CITY OF ALBUQUERQUE

**RE: Cosme Retail – 6205 Central Ave. NW
Request for Certificate of Completion
Hydrology Final Inspection – Disapproved
Engineer’s Stamp Date: 3/15/2017 (K11D077)
Certification Date 1/24/2018**

GRADING & DRAINAGE PLAN

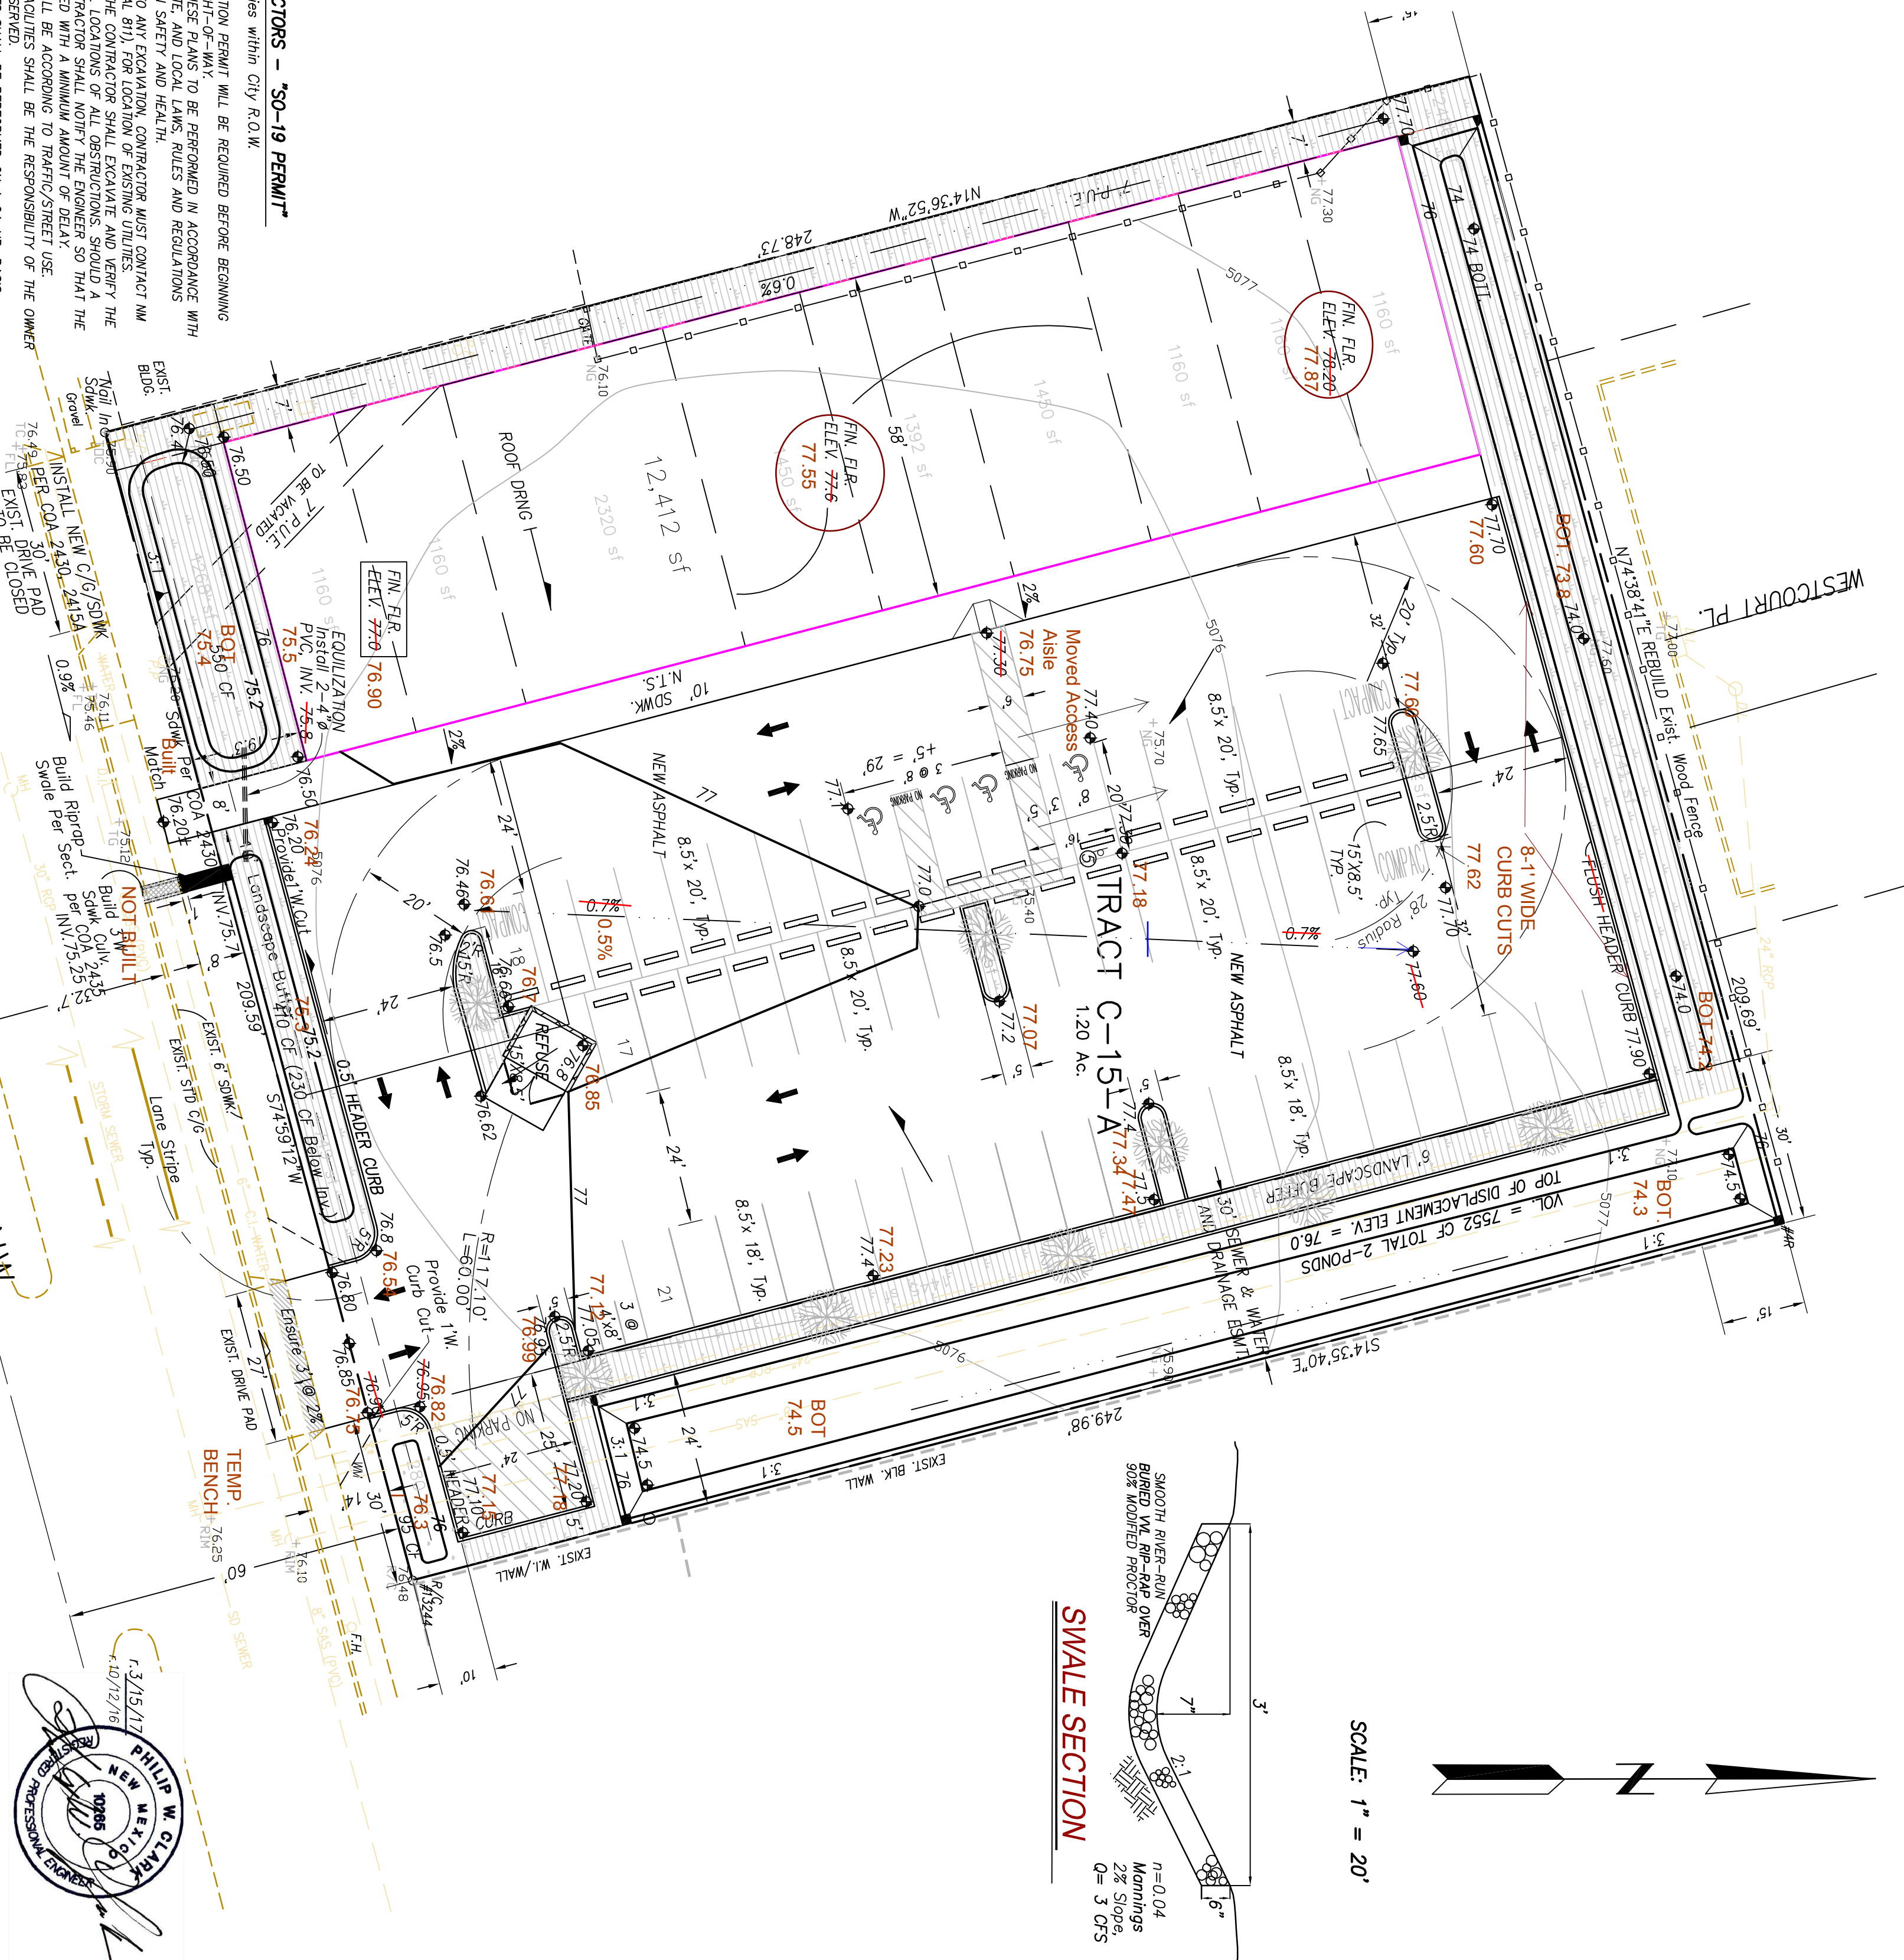
3. The as-built elevations show that the driveway water-block was constructed between 0.13' and 0.26' lower than planned, and may be lower than the COA STD DWG 2425 for Driveways. Dimension L on the standard detail is measured from the top of curb, so both top of curb and property line elevations should be shown on the certification and any deviation noted and justified in the certification statement with supporting calculations on the plan or under separate engineer's stamp.

4. The sidewalk culvert must be built before CO, because we do not allow drainage over the sidewalk on Arterial and Collector streets. An SO-19 permit is required for the sidewalk culvert construction in the public R/W and Jason Rodriguez will need to inspect it after it is complete and send us his approval (see SO-19 notes on the approved G&D Plan).

5. The first flush pond south of the parking lot is missing and needs to be graded per plan. The pond south of the building also lacks volume. The volume below the sidewalk culvert invert must not be less than is shown on the approved plan and must be specifically included in the certification. Extra volume in the other ponds does not compensate for the missing volume in these two ponds. The diameter and inverts of the 4" pipes connecting the two ponds needs verified. Drainage from the parking lot must be prevented from flowing onto the sidewalk connection to Central by adding a header curb between the parking lot and the sidewalk, and a curb cut need to direct drainage from the parking lot into the pond.
6. After these items have been addressed a new application must be turned in with a new DTIS form and the building permit number must be filled in on the form.
